DORAN DRIVE PRECINCT SHOWGROUND

RESPONSE TO STATE DESIGN REVIEW PANEL - MEETING 3

DEICORP PROJECTS (SHOWGROUND) PTY LTD

Please find below a summary of detailed response prepared by the project team to address the items raised in the letter dated 19th November 2021 by State Design Review Panel. State Design Review Panel meeting was held on 10th November 2021.

# 3.6 LEVEL 2 PODIUM PROGRAM

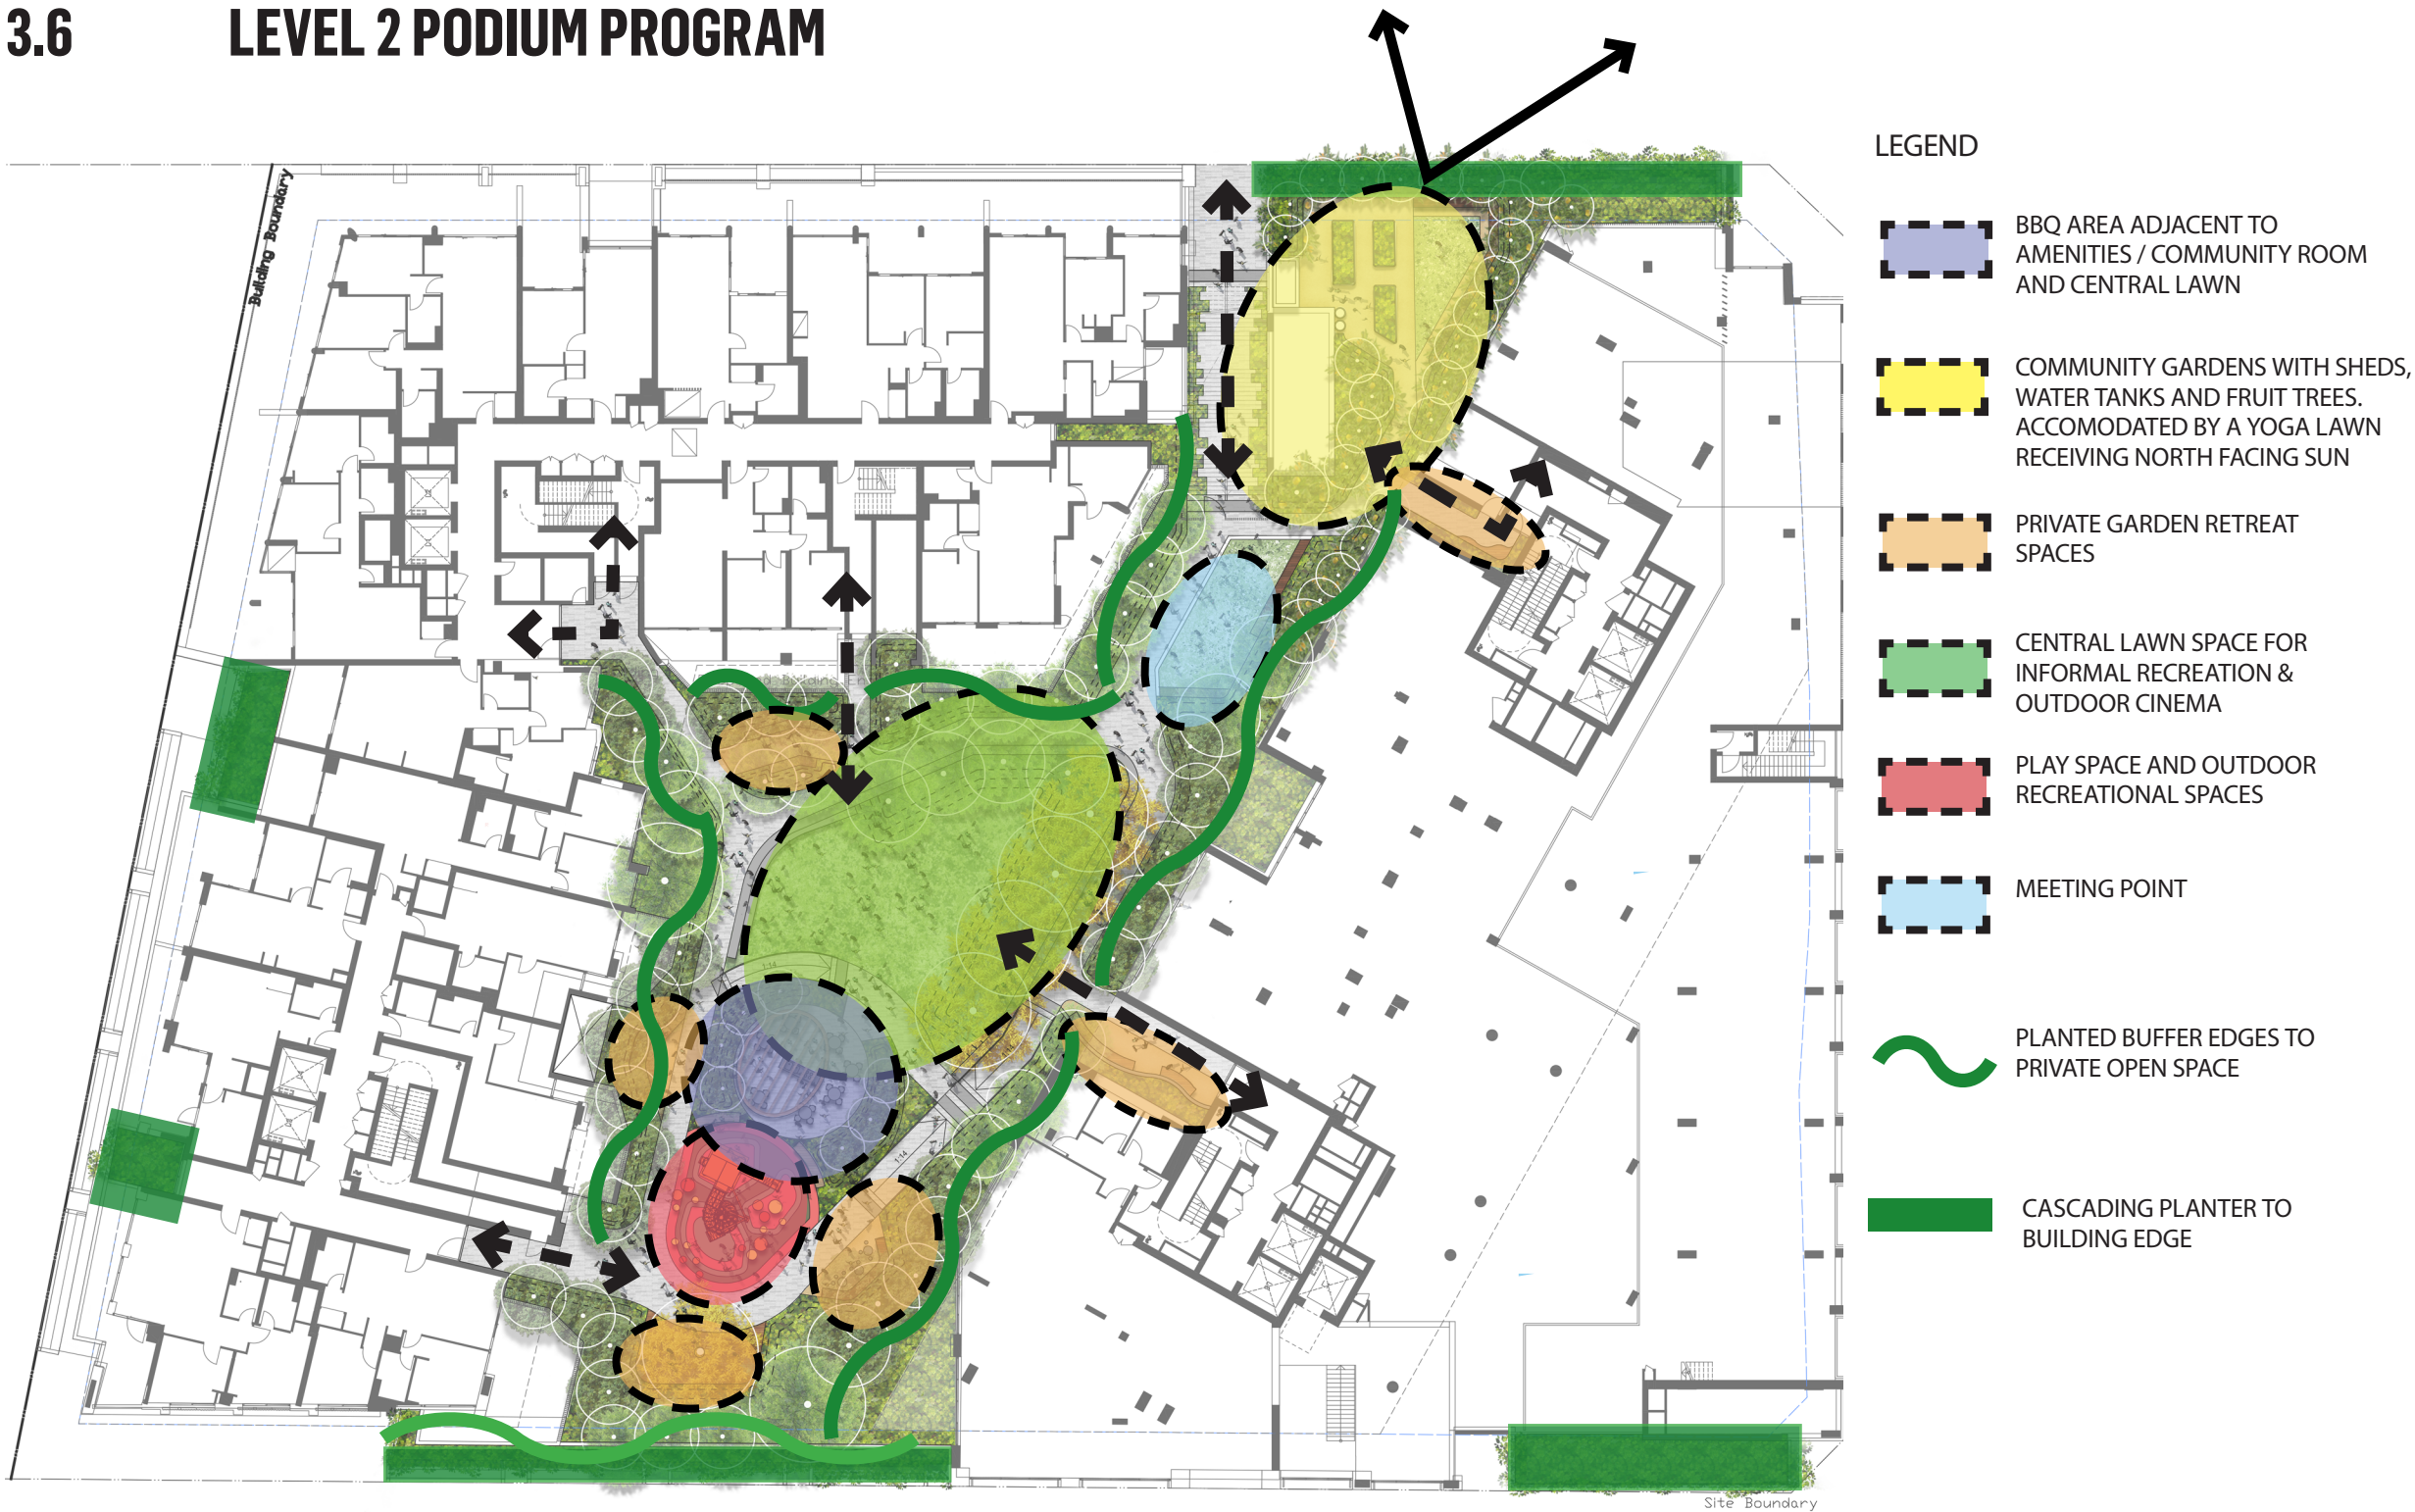
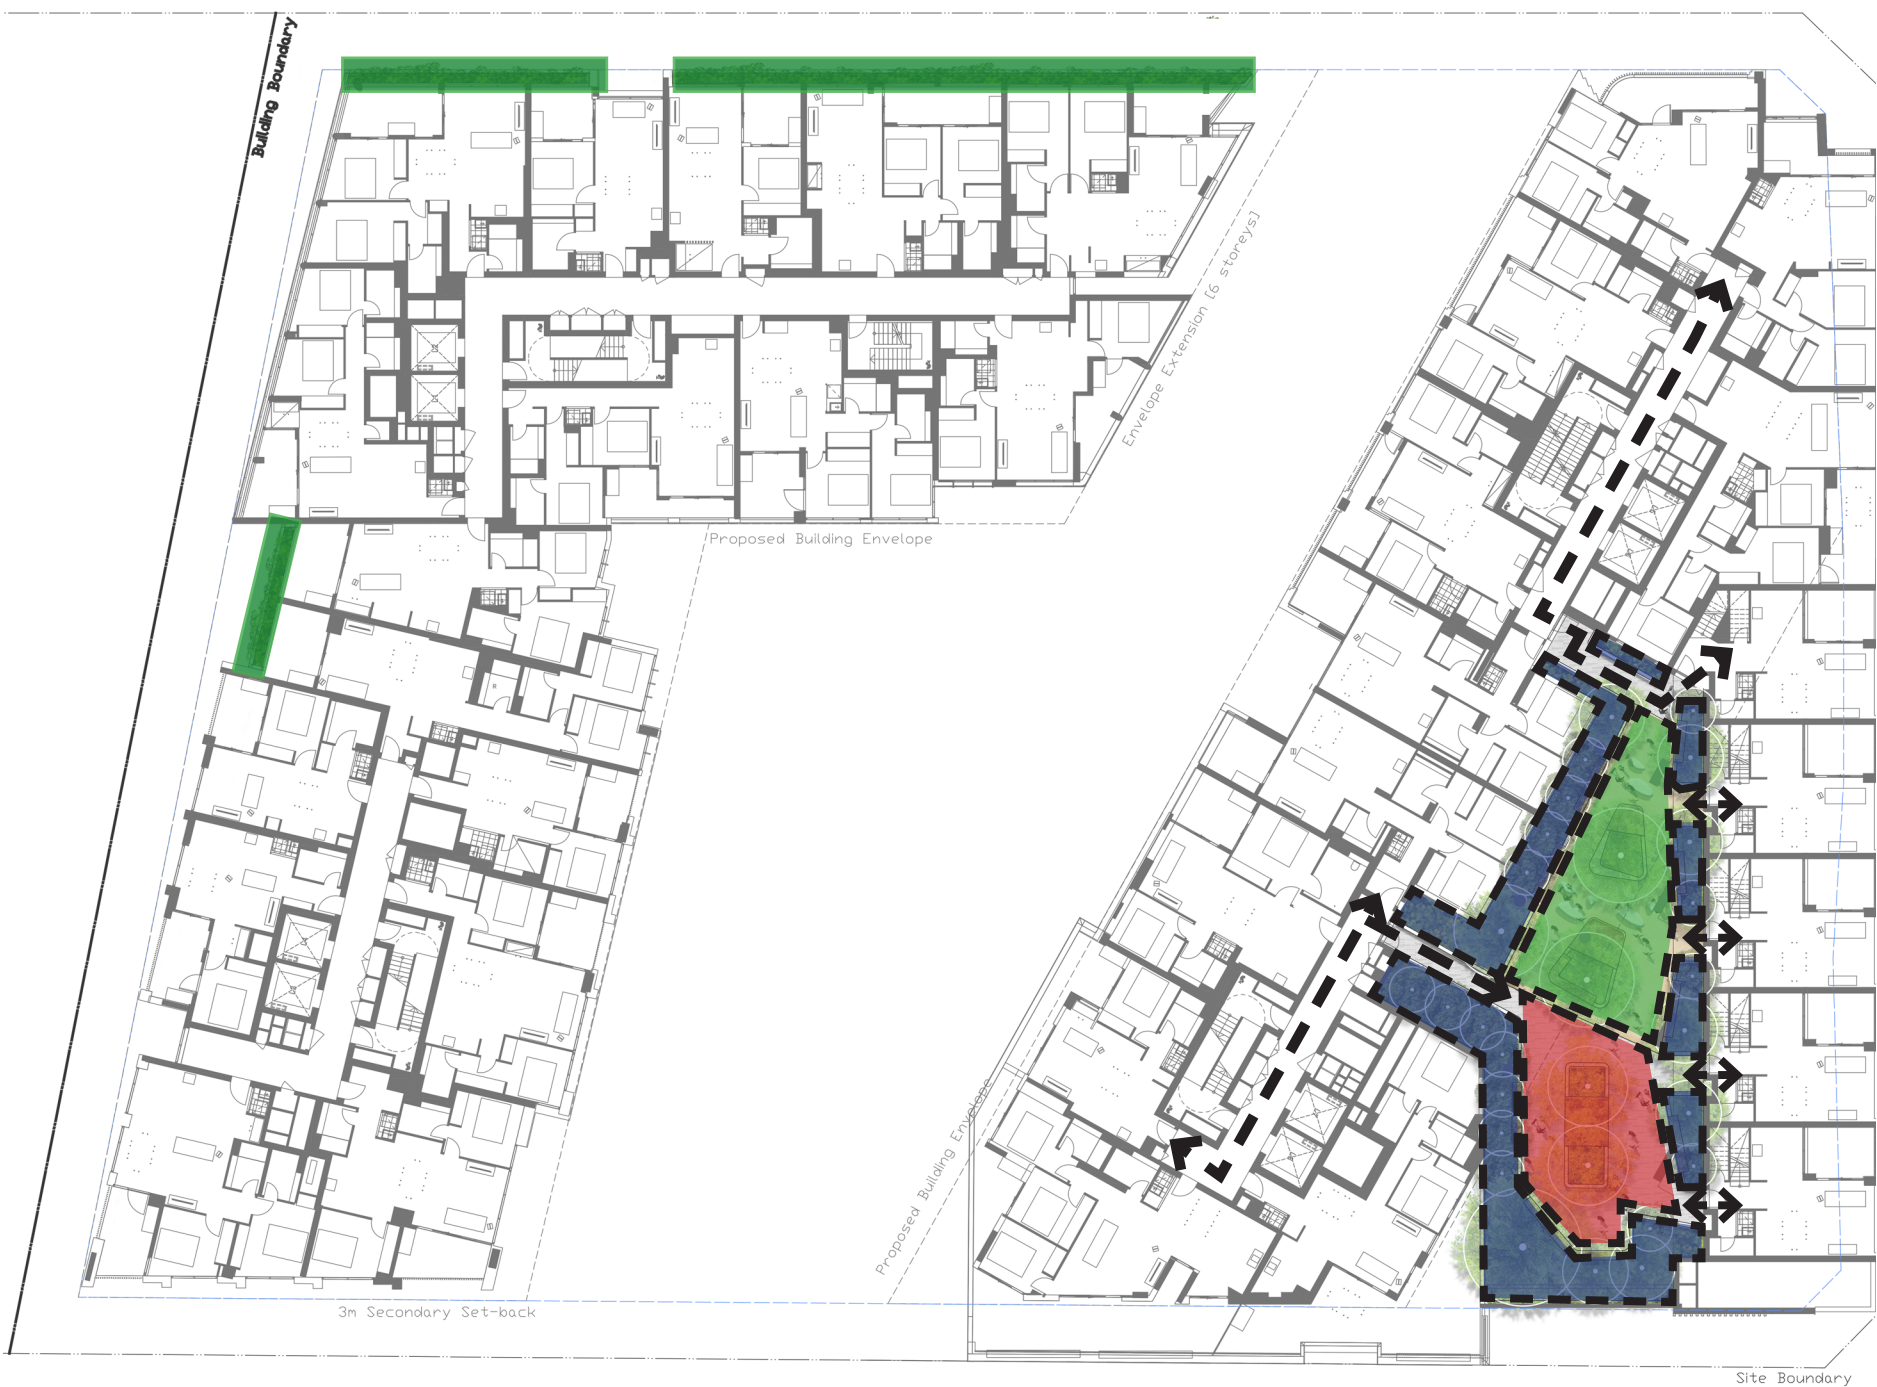
SDRP Comment	Consultant	Response
1. MASTERPLAN/ PUBLIC SPACE		
Amenity And Activation		
<p><i>There are still concerns in relation to the amenity and activation of open spaces. In particular please note the following:</i></p> <ul style="list-style-type: none"> • 3D visualizations are required to illustrate the quality and character of spaces - showing proportion, materiality, amenity and intended activation of the key public spaces - thru site link, Doran Drive Plaza and the communal open space above the podium. 	<p>Urbis Mark Kuhne Director / Registered Landscape Architect #1226 (AILA)</p>	<p>A large package of professional CGI renders has been commissioned for the SDRP 4 presentation. These CGIs cover all parts of the public domain, podium/street interface, the residential garden podiums and towers overhead. The CGIs illustrate the high quality and character of the proposed spaces. They illustrate the scale of the spaces, the activation and programs, materiality and planting.</p> <p><u>Doran Drive Plaza</u> Doran Drive Plaza is intended to be a high quality, flexible urban open space that functions both as a permeable connection between the Metro station, buses, retail and the Castle Hill Showground, as well as providing an activated and comfortable space for people to use and inhabit day to day.</p> <p>The plaza includes:</p> <ul style="list-style-type: none"> • Interpretive feature paving Celebrating First Nations People Songlines along the “creeks” with a series of small and medium scale meeting places and interpretive signages • Central open plaza with water feature • Amphitheatre and lawn area to the north for informal recreation, markets and events • Active retail edges to the east • Native shade trees and low-level planting to the southern part of the plaza, incorporating opportunities for public seating, marketplace and gathering • Integrated lighting • Grade changes to be made up at the edges of the Site to provide minimal grading across the majority of the plaza • Opportunities for Public Art and interpretation. <p><u>Communal Open Spaces</u> <u>Level 2</u> Level 2 communal space provides a large communal podium landscape that encourages community gathering and activities. The planting scheme for this podium landscape is to not just use shade tolerant species that respond to the sun and shade analysis diagrams but also use species from the Shale / Sandstone Transition Forest vegetation community.</p> <p>Proposed amenities include a large play space with feature play items and adjacent seating for parental supervision. Connected to this space is a BBQ pavilion area with BBQ facilities and dining spaces. The feature of the podium landscape is central lawn space with mounding for feature Jacarandas, amphitheatre seating to the edge, providing informal recreation and outdoor cinema space. Throughout the podium there are private garden retreat spaces with seating surrounded by planting. To the north of the podium adjacent to the community room is the community garden to allow</p>

<p>residents to take ownership of this part of the garden and interact with the community.</p> <p><u>Level 3</u> Level 3 communal space provides a larger communal rooftop for the residents to enjoy. This courtyard garden consists of a lush buffer to the building edges for privacy in the courtyard and the residents' apartments. This level has introduced the Shale / Sandstone Transition Forest vegetation community. While also providing cascading planting to the western building edge.</p> <p>This courtyard provides two designated areas within the courtyard, the northern part is a decomposed gravel gathering space with feature trees in bespoke planters, generous seating benches and moveable furniture for gathering. The southern part of the courtyard is a paved garden with central planters with larger relaxation, lounge seating areas.</p> <p><u>Level 6 & 8</u> Level 6 & 8 provides rooftop gardens for the residents to enjoy. Both these gardens provide lush landscape planted edges with species from the Sydney Turpentine Ironbark Forest as well as exotic shade loving species. The species have been selected to work with both microclimates to ensure the planting will grow and provide a lush landscape.</p> <p>The larger eastern courtyard provides residents with three flexible places to gather and relax. The northern part of the courtyard provides a paved enclosed gathering space with a central bespoke planter with seating incorporated into the edge planters. The centre of the rooftop provides a central nodal gathering space with flexible and moveable furniture. The southern part of the rooftop is a larger courtyard space that provides seating to the edge planters and a central planter and larger relaxation lounging timber deck. While the western courtyard provides a secluded gathering space for residents to relax and retreat too surrounded by lush planting.</p> <p><u>Level 9</u> Provides an oasis for the residents; a small pocket of an outdoor space for them to enjoy. This level provides lush native planting to the courtyard edge from the Sydney Turpentine Iron Bark Forest. In addition, we have also introduced exotic shade loving species that will thrive in this location. As this level is also in shade all day, the species selected for this level are chosen to suit the condition. The courtyard also provides a small gathering space with seating benches to the planter edges and larger seating benches for group gatherings. This level also provides a podium edge cascading planters to add to the effect of the building facade.</p>
